WEST SUSSEX COUNTY COUNCIL CONSULTATION

TO:	Arun District Council FAO: Hebe Smith
FROM:	WSCC – Highways Authority
DATE:	25 August 2026
LOCATION:	21 Longford Road Bognor Regis PO21 1AB
SUBJECT:	BR/134/26/PL Change of use from dwelling house (use class C3) to 8-bed, 8-person house in multiple occupation (Sui Generis) to include a rear extension and loft conversion. This application is in CIL Zone 4 (Zero Rated) as other development.
DATE OF SITE VISIT:	n/a
RECOMMENDATION:	Advice

NOTES:

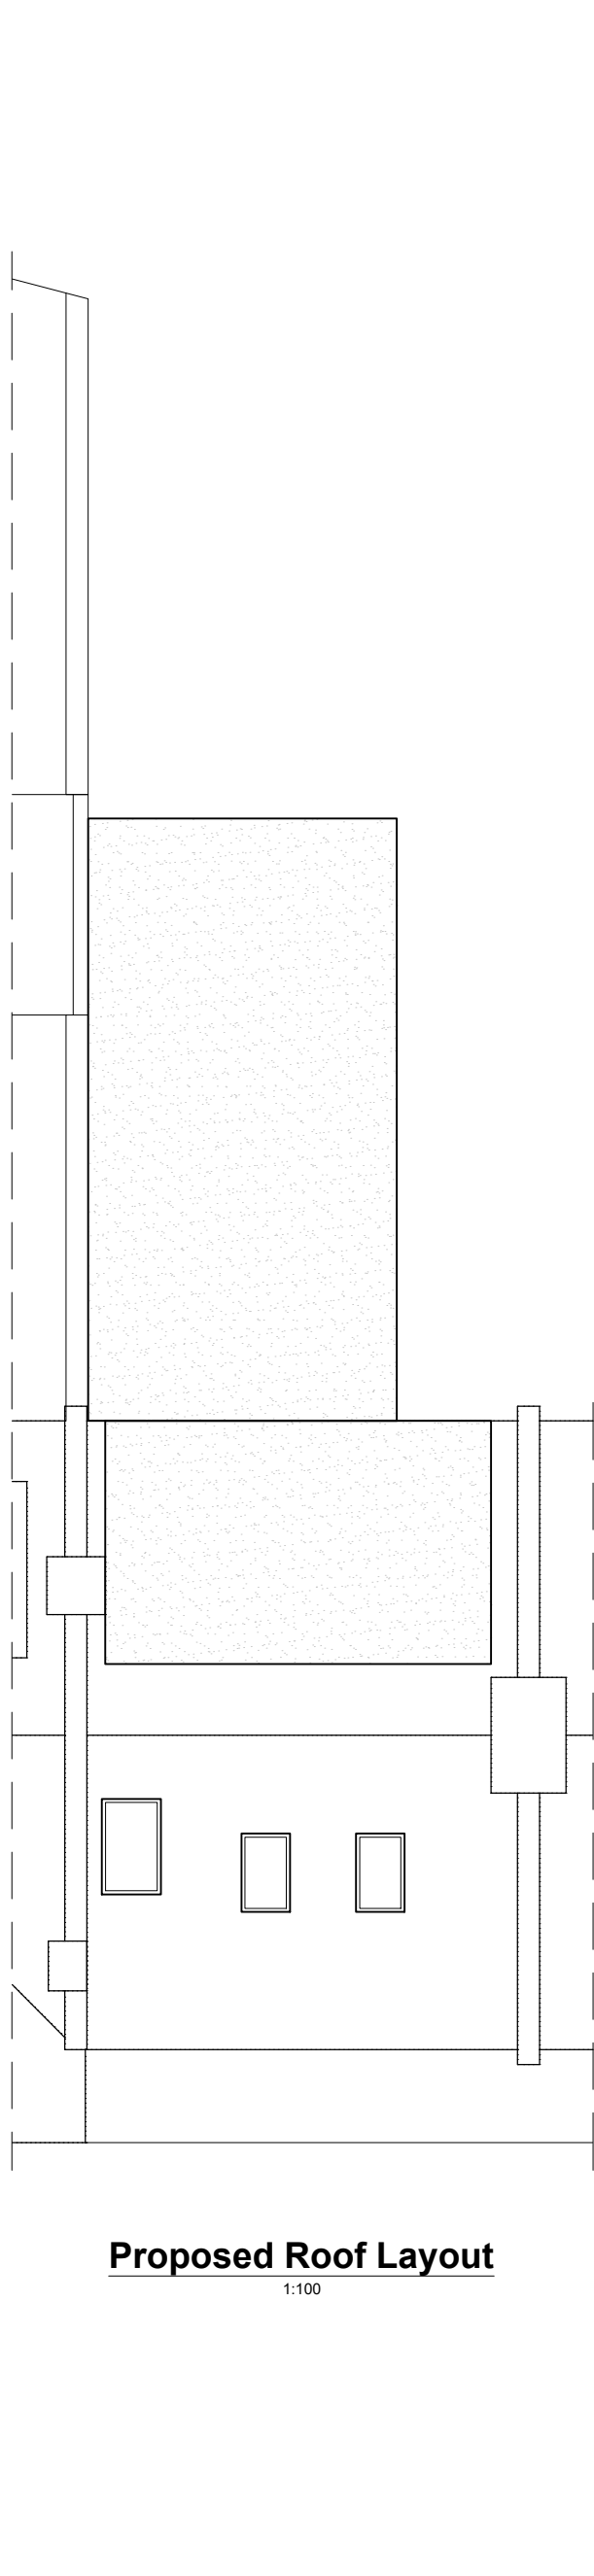
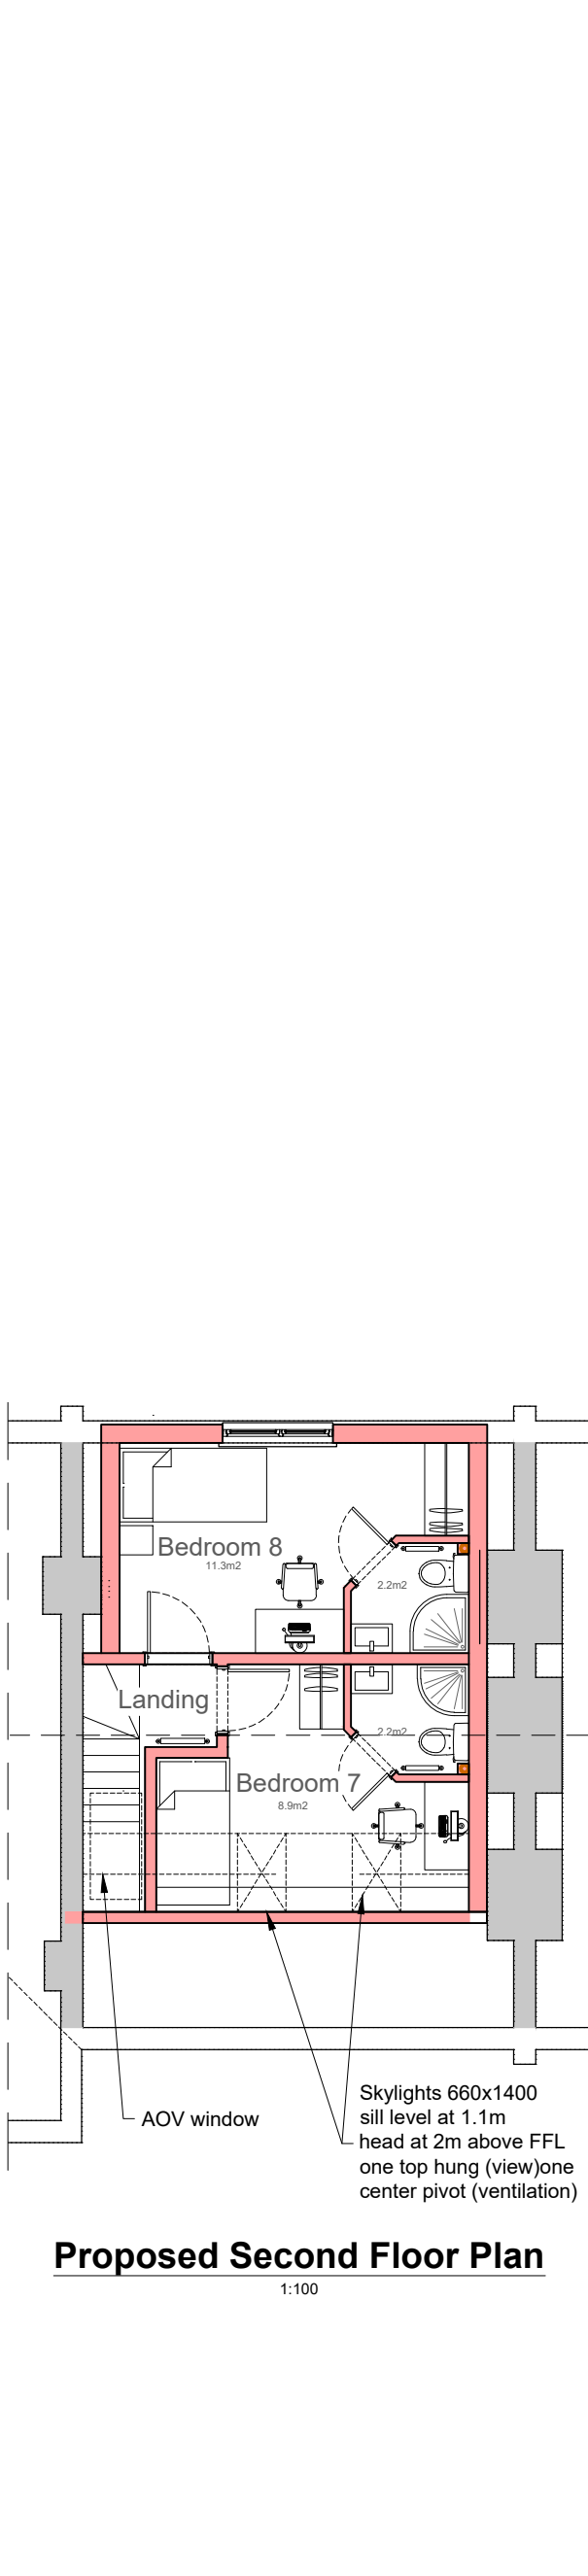
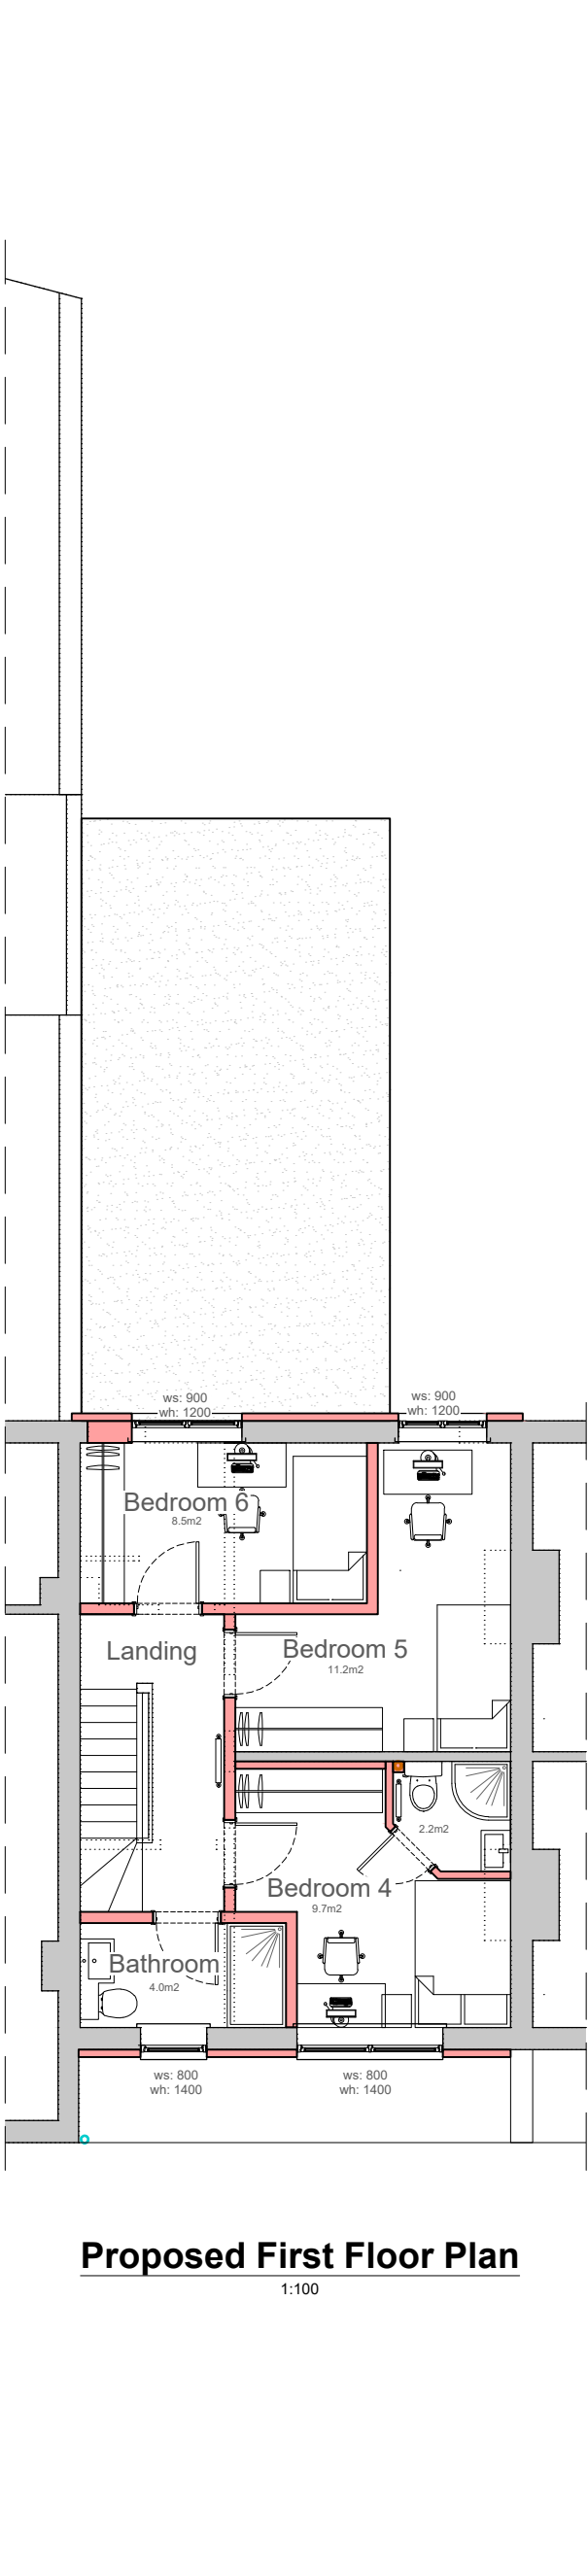
Provision for the storage of bicycles has been demonstrated to the rear of the site. The cycle parking proposed appears to be in the form of vertical hanging racks. The LHA would advise that Sheffield stands are preferred due to their ease of access. Sheffield stands should be spaced in accordance with the guidance in Manual for Streets (Figure 8.6 page 102). Whilst stands other than the Sheffield can be acceptable, vertical hanging racks and butterfly stands only allow the front wheel to be secured. These types of stands can be difficult for some users to lift their bike into position and don't allow users to easily secure the frame and both wheels; so are less secure.

The details of the cycle parking provision can be secured via a suitably worded condition- advised below.

No part of the development shall be first occupied until covered and secure cycle parking spaces have been provided in accordance with plans and details to be submitted to and approved by the Local Planning Authority.
